P20005-R2-TIS-redlines.pdf Markup Summary

Figure 12

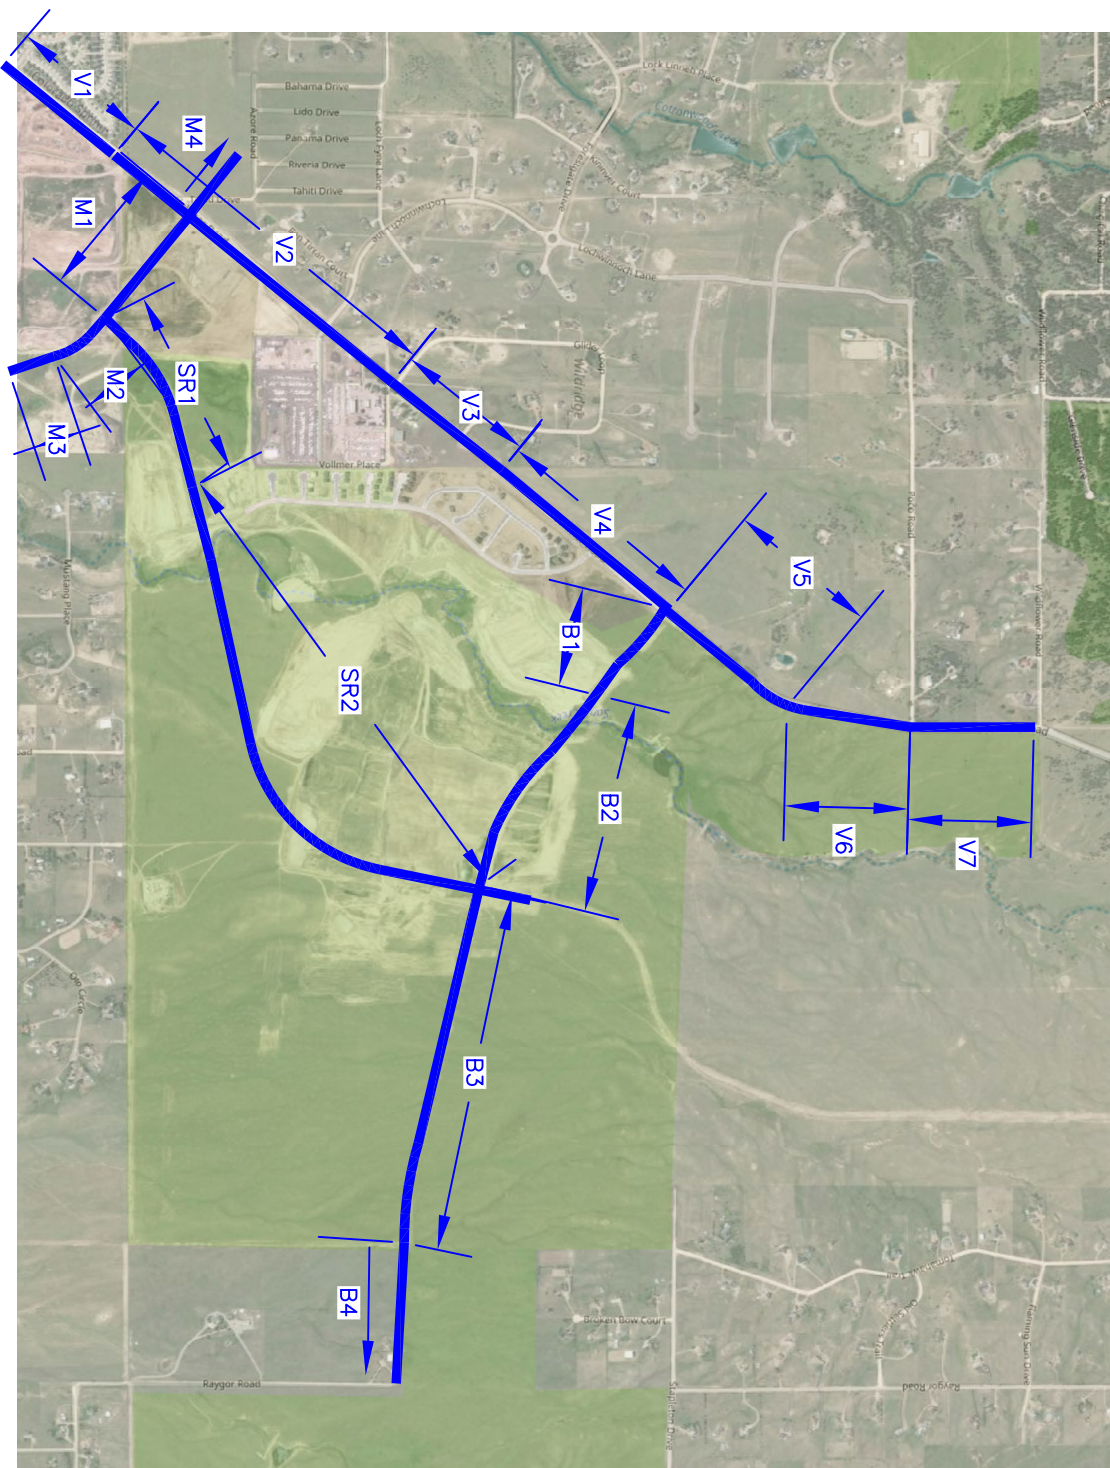
Subject: Cloud+ Auxiliary Turn Lanes
Page Index: 14
Date: 4/21/2021 9:20:47 AM
Author: dsdrice
Color: ■
Layer:
Space:
Page Label: 14

Subject: Callout 13?
Page Index: 18
Date: 4/21/2021 9:23:16 AM
Author: dsdrice
Color: ■
Layer:
Space:
Page Label: 18

Subject: Fil 1
Page Index: 18
Date: 4/21/2021 9:38:24 AM
Author: dsdrice
Color: ■
Layer:
Space:
Page Label: 18

Subject: Fil 1
Page Index: 18
Date: 4/21/2021 9:43:03 AM
Author: dsdrice
Color: ■
Layer:
Space:
Page Label: 18

Subject: Callout and 2?
Page Index: 18
Date: 4/21/2021 9:46:38 AM
Author: dsdrice
Color: ■
Layer:
Space:
Page Label: 18

Intermediate?

ement for two 11' southbound lanes
markings), a 12' northbound lane and a 4'
edge" [in City of Colorado Springs](#)
e Place to Markshoffel Road to a standard 4-
an (Add a second northbound through lane

in City of Colorado Springs

Stapleton Road

in City of Colorado Springs

in City of Colorado Springs

in City of Colorado Springs

Or€
Sterling€Ranch€Phase€2€

Delete

with€€
Improvement€5)€

Phase 2
